CITY OF ALBUQUERQUE

Planning Department
David Campbell, Director

RE: **Fiesta Kia Auto Group**
7400 Lomas NE
Grading and Drainage Plan
Engineer's Stamp Date: 5/14/18
Hydrology File: K19D152

Based on the submittal received on 5/16/18, the Grading and Drainage Plan cannot be approved for building permit until the following comments are addressed:

C-101A
SHEET OF

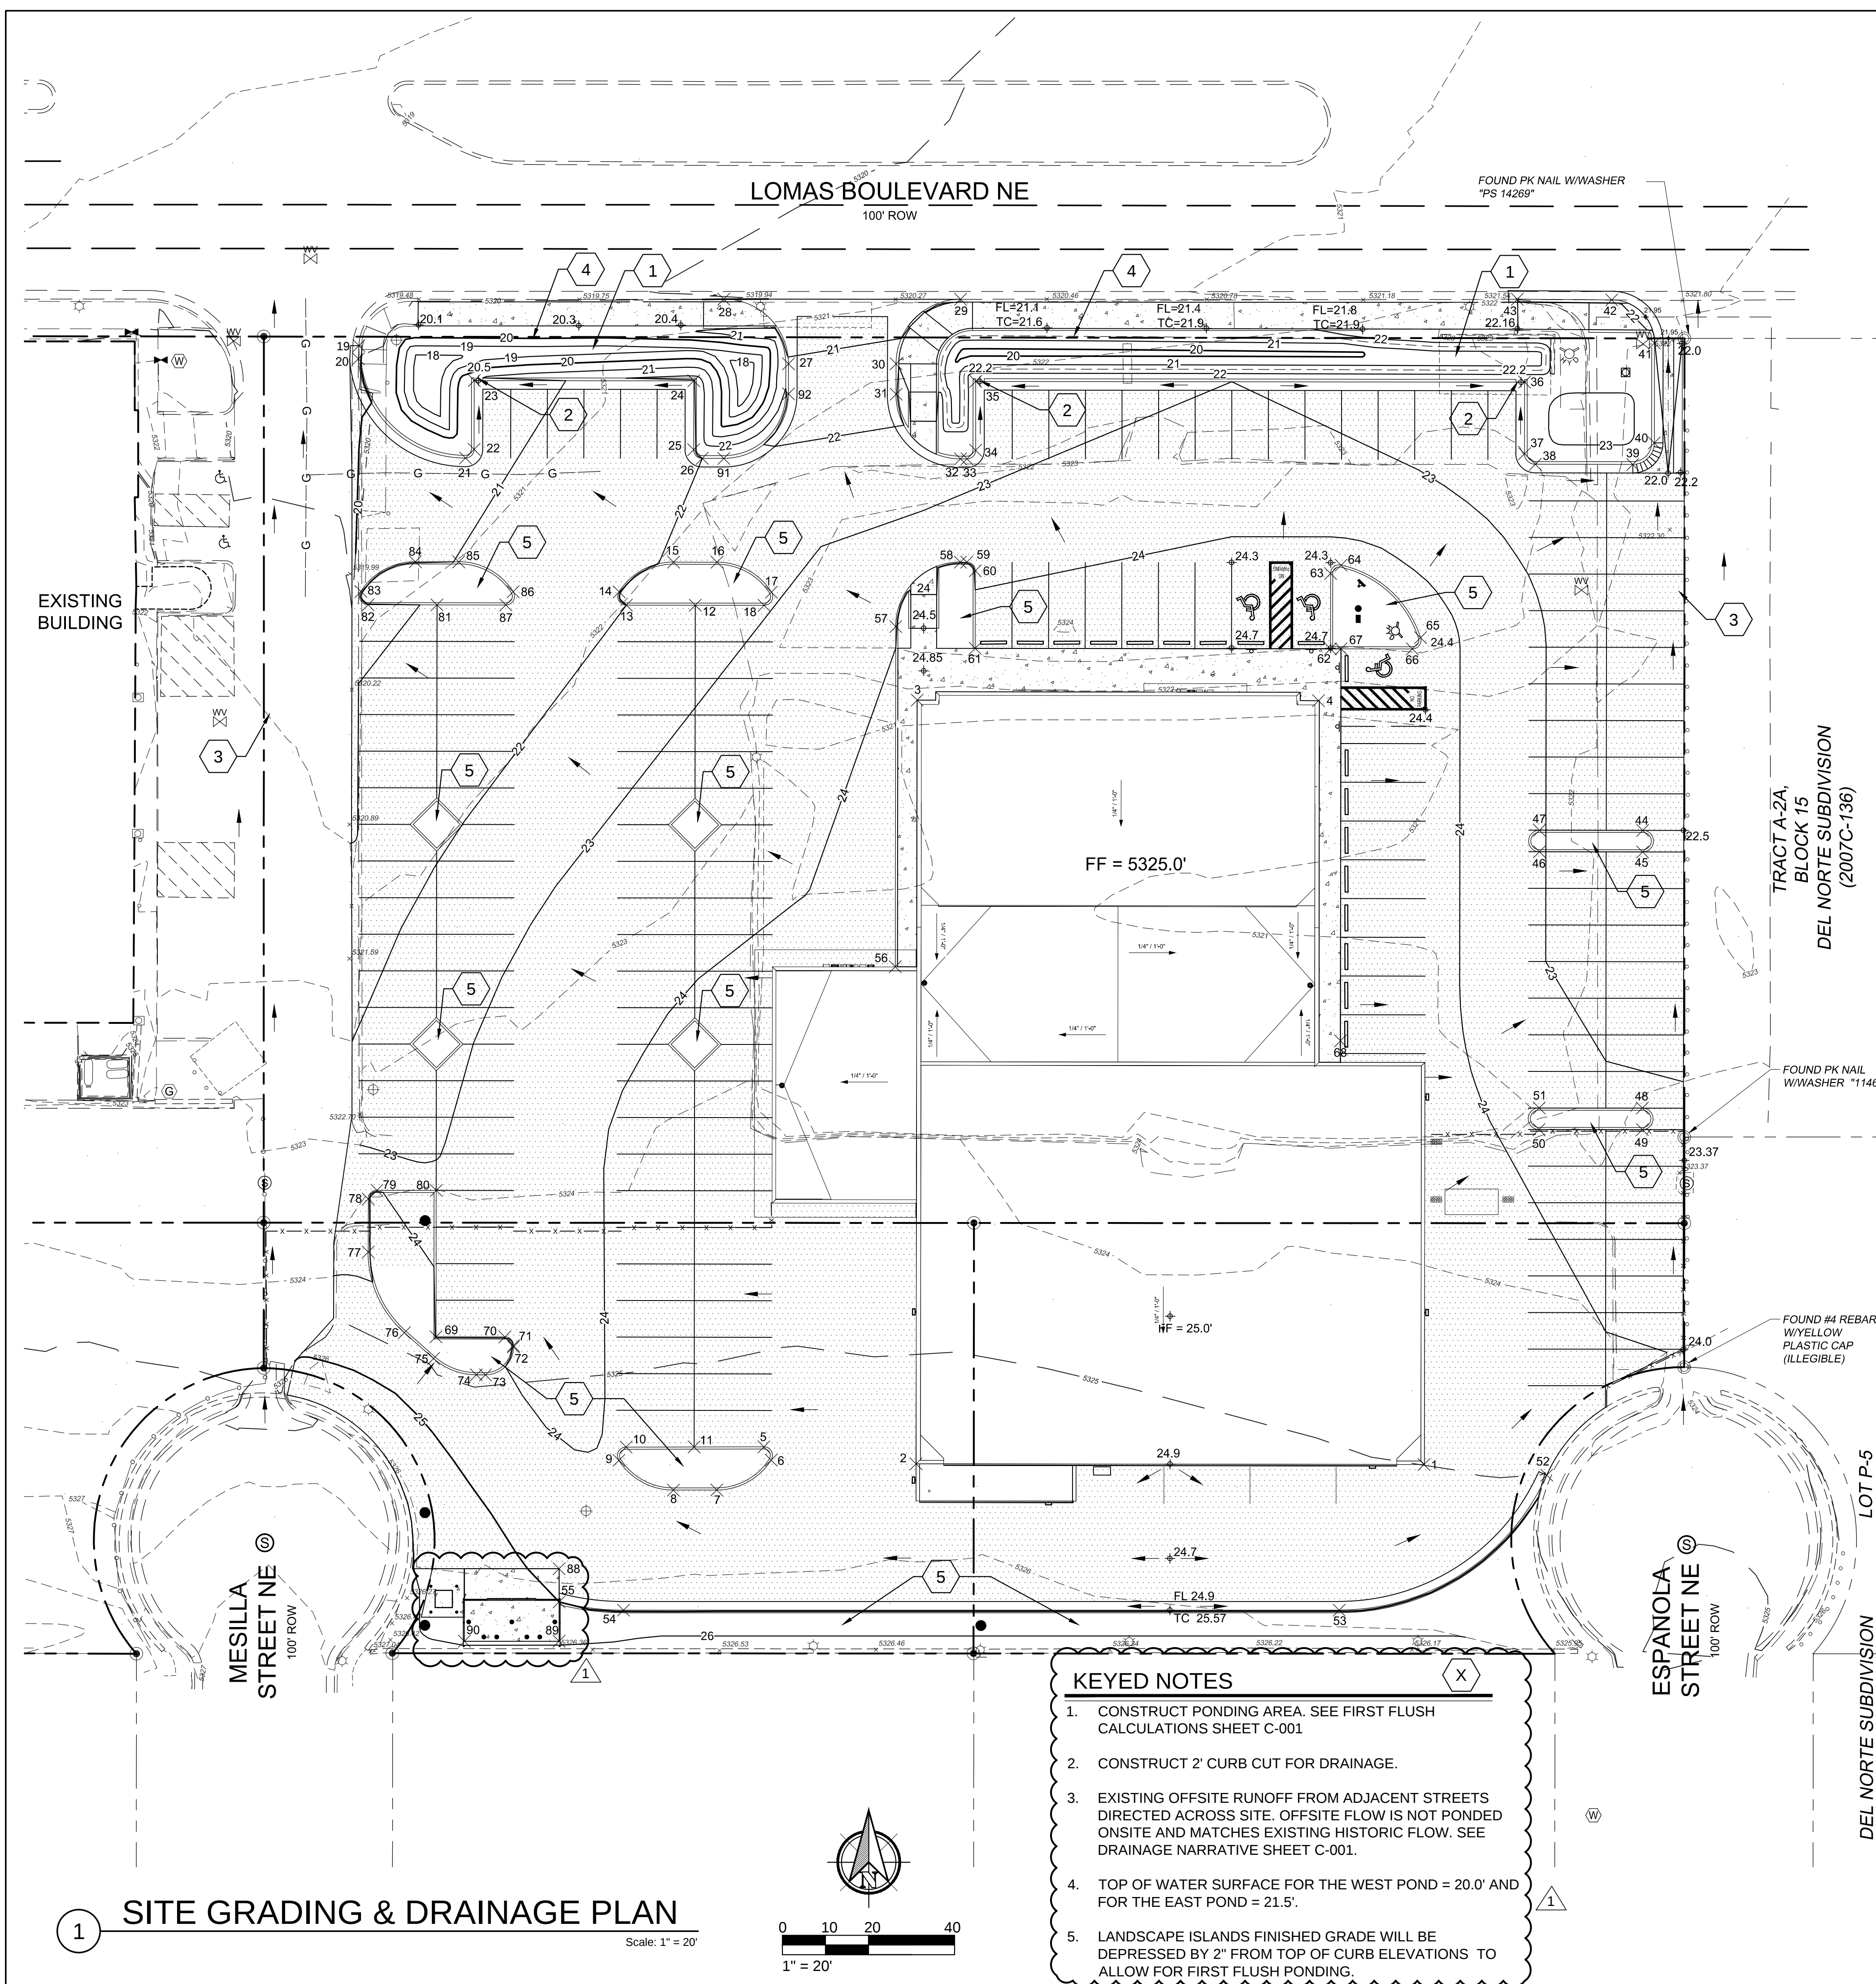
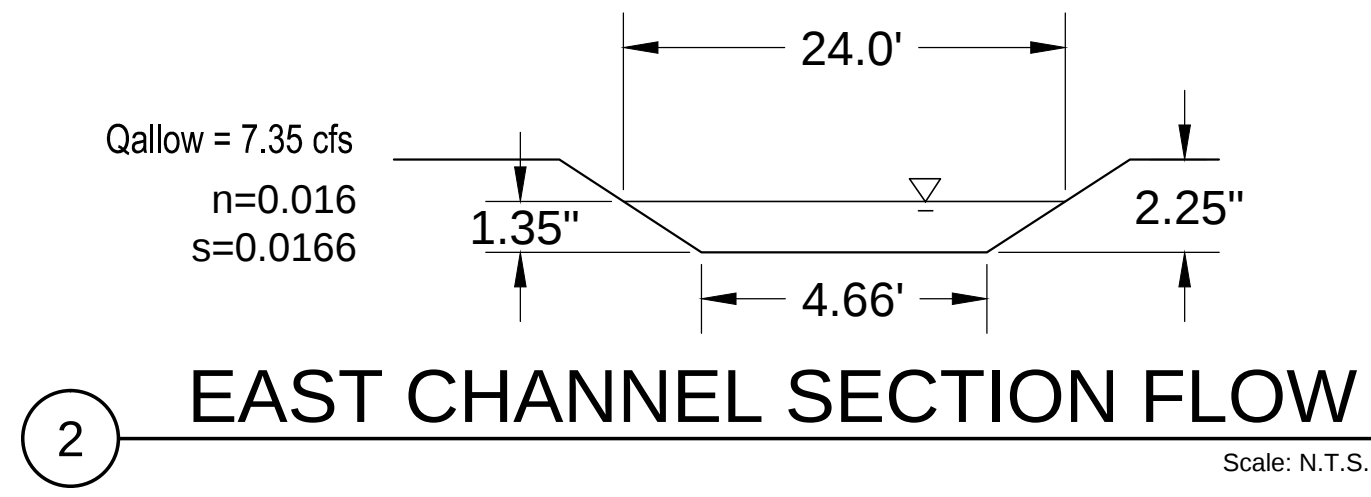
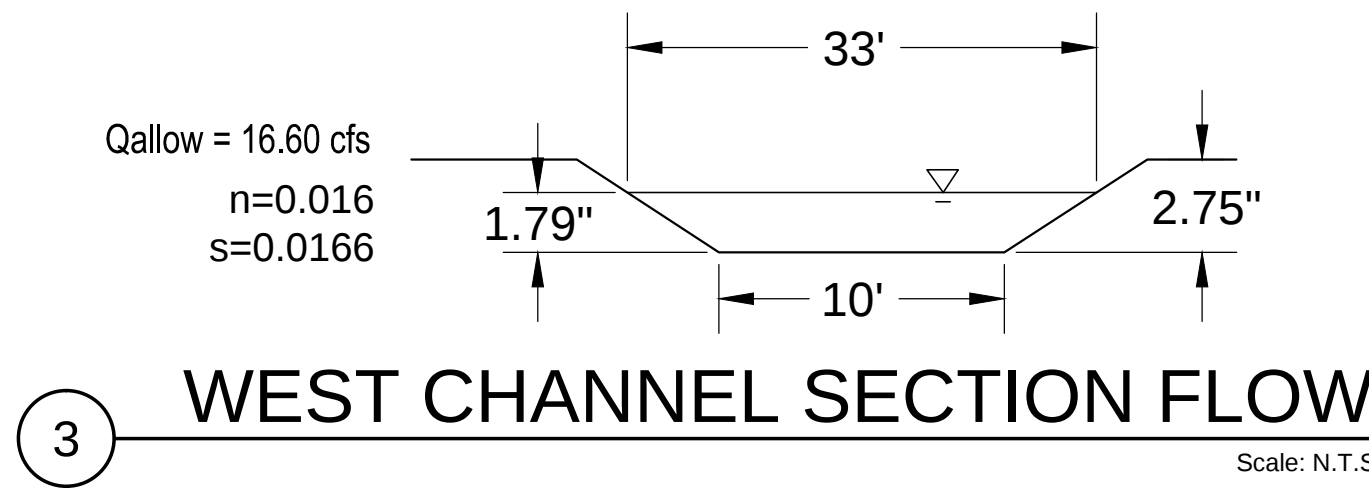
3. Provide a subbasin delineation map/exhibit demonstrating that all impervious runoff from the site is routed through the first flush ponds. Each pond must be sized for the area draining to it.

4. Payment of Fee-in-Lieu is an option if any of the impervious area runoff cannot be captured onsite. Quantify the volume that bypasses the ponds and state on plans; Fee-in-Lieu will then be required at a rate of \$8/cf of bypass volume.

9. Please ensure the capacities through the easements are maintained; the offsite flows need to be quantified and capacity calculations provided. Provide cross sections through each showing existing/proposed conditions, easement lines, property lines, and dimensional data.

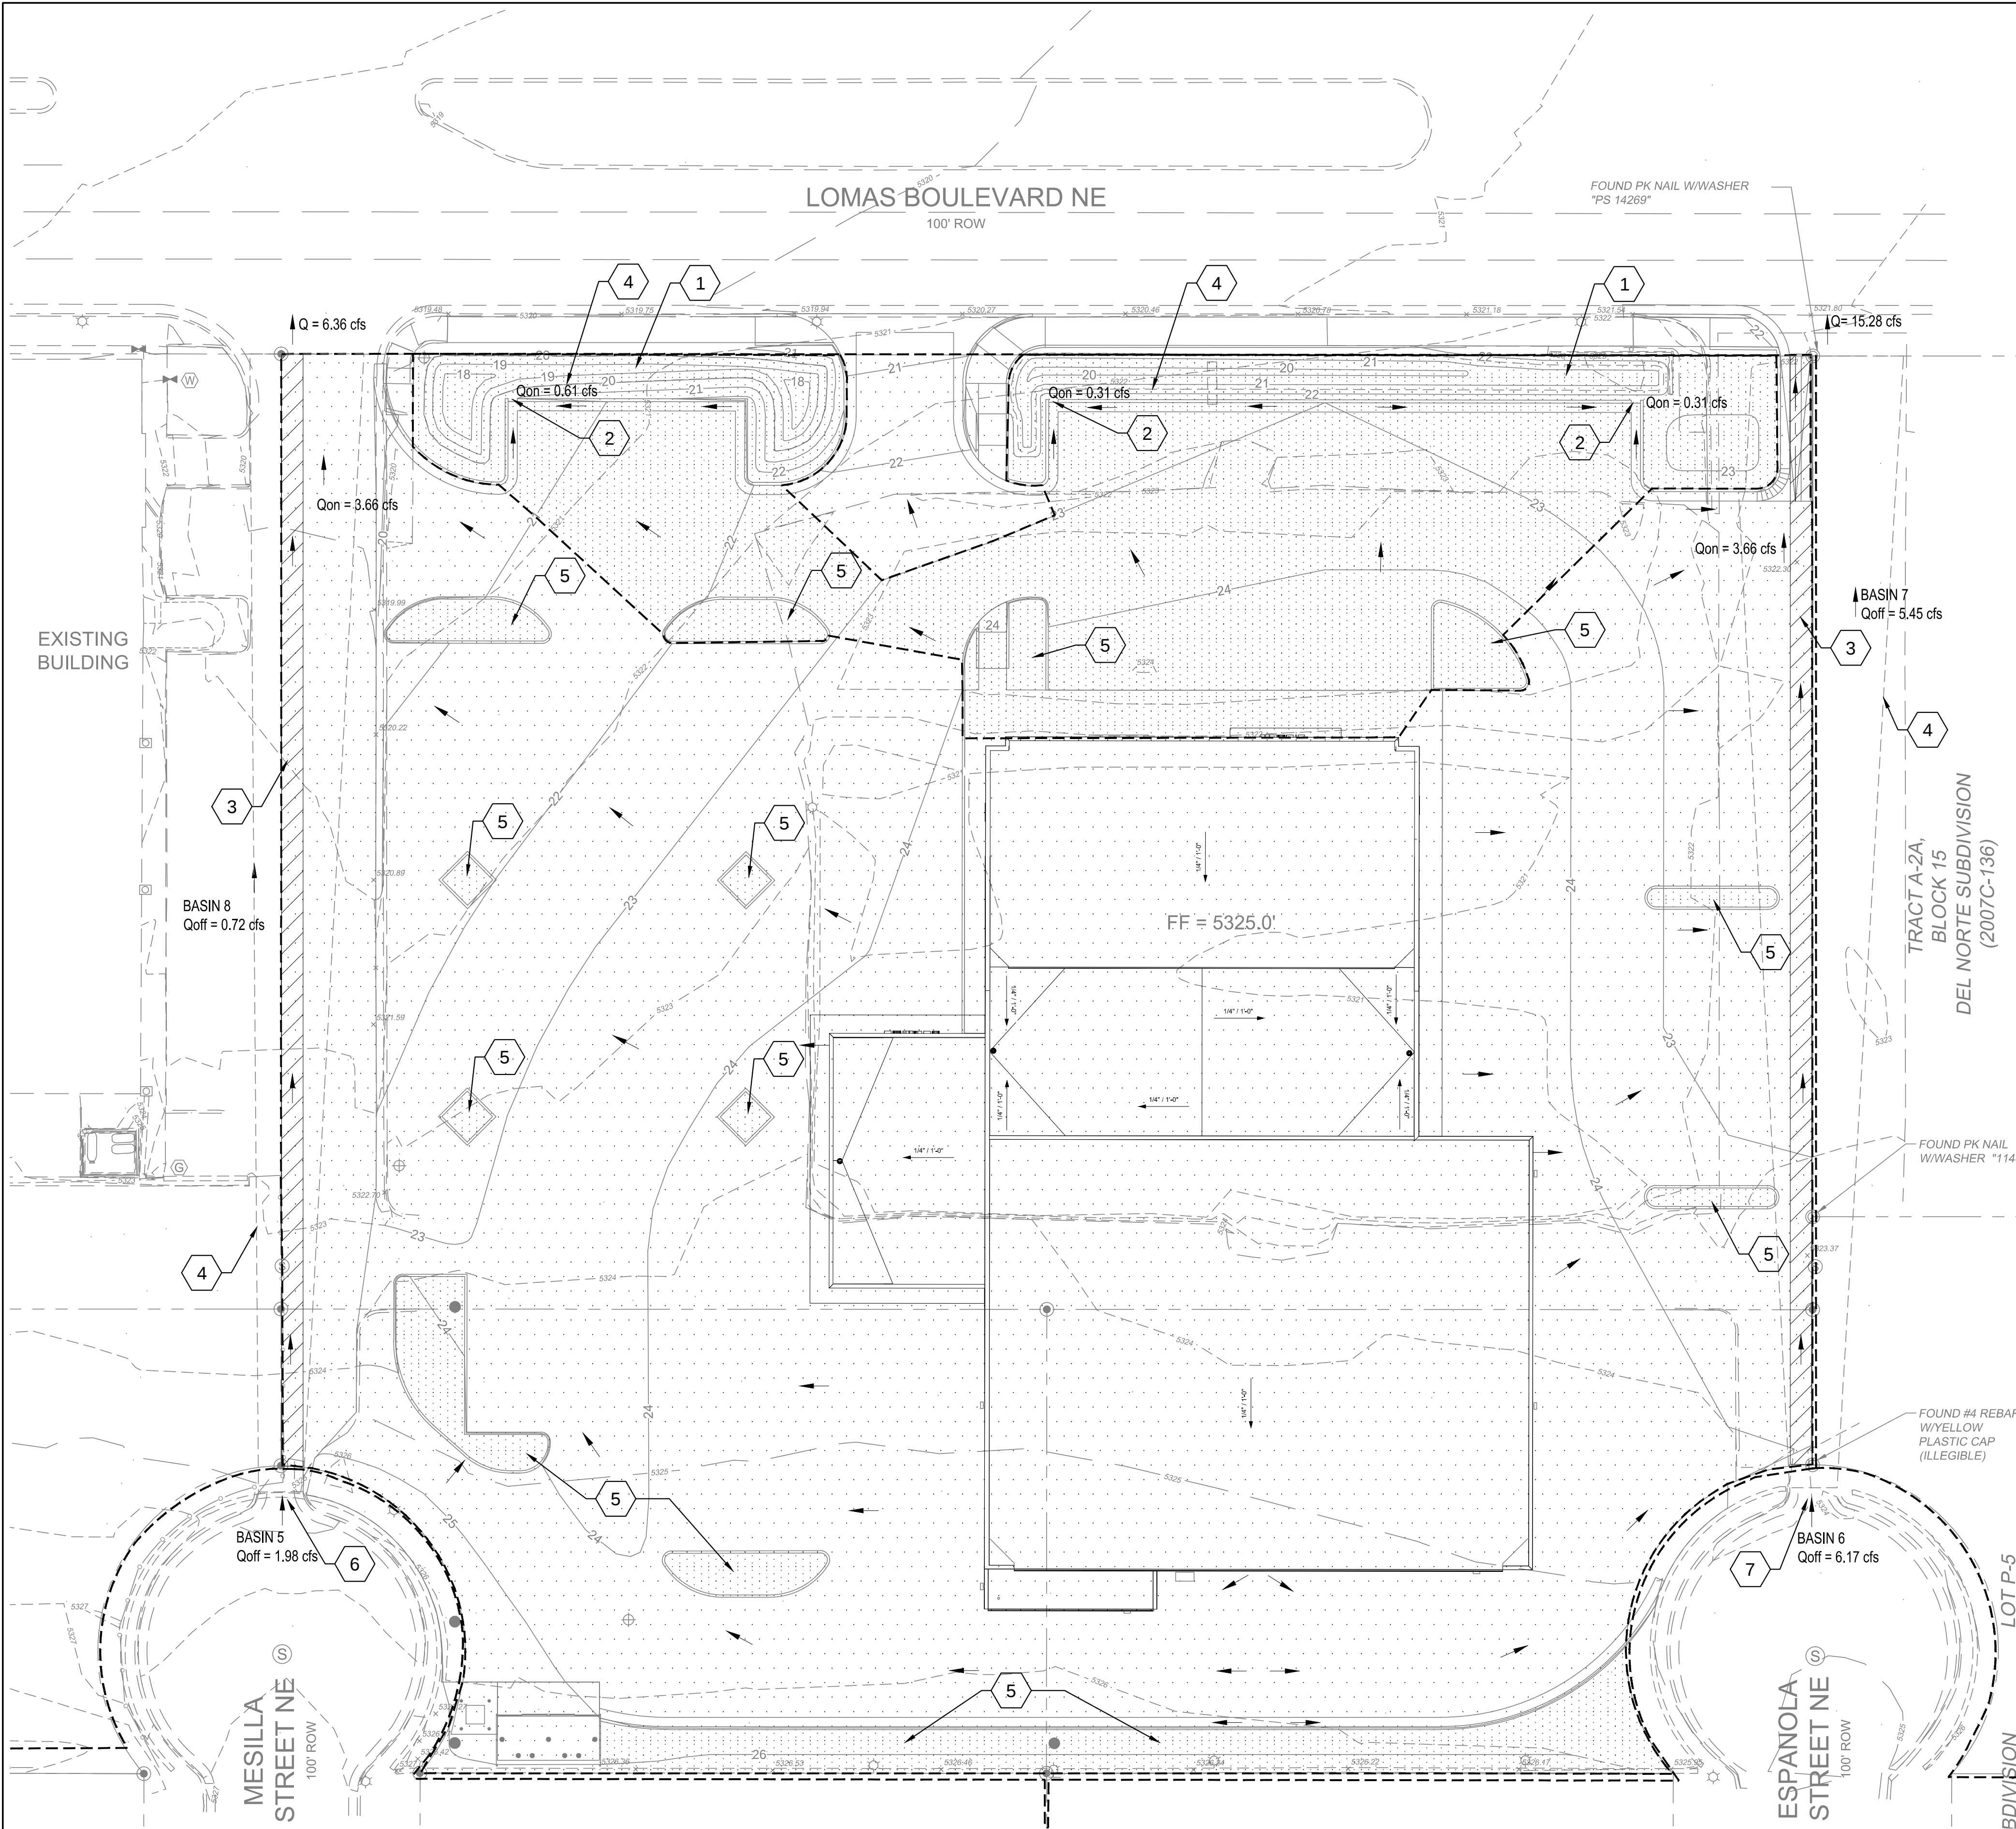
2. Existing and proposed hydrology needs to be provided. Clearly show existing vs proposed flow patterns, demonstrating that the site has and will drain to Lomas (and not cross-lot). Any increase in runoff will need to be ponded onsite, unless downstream capacity can be demonstrated.

5. How will flows enter the ROW once the first flush pond fills up? Spilling flows over the sidewalk on arterial roads is not permitted; sidewalk culverts are likely required.

7. Provide survey data along the south side of the site (both sides of the wall). Do not cut or fill against the existing wall.
8. Label any drainage easements; impervious runoff from within the easements does not need to be captured.

10. Are any walls, fences or obstructions being proposed down either of the drainage easements? This may be feasible, but capacity will need to be demonstrated. An encroachment agreement would also be required, but may not be approved; further discussion with the City Engineer and Drainage Engineer is recommended if desiring to obstruct the easements.
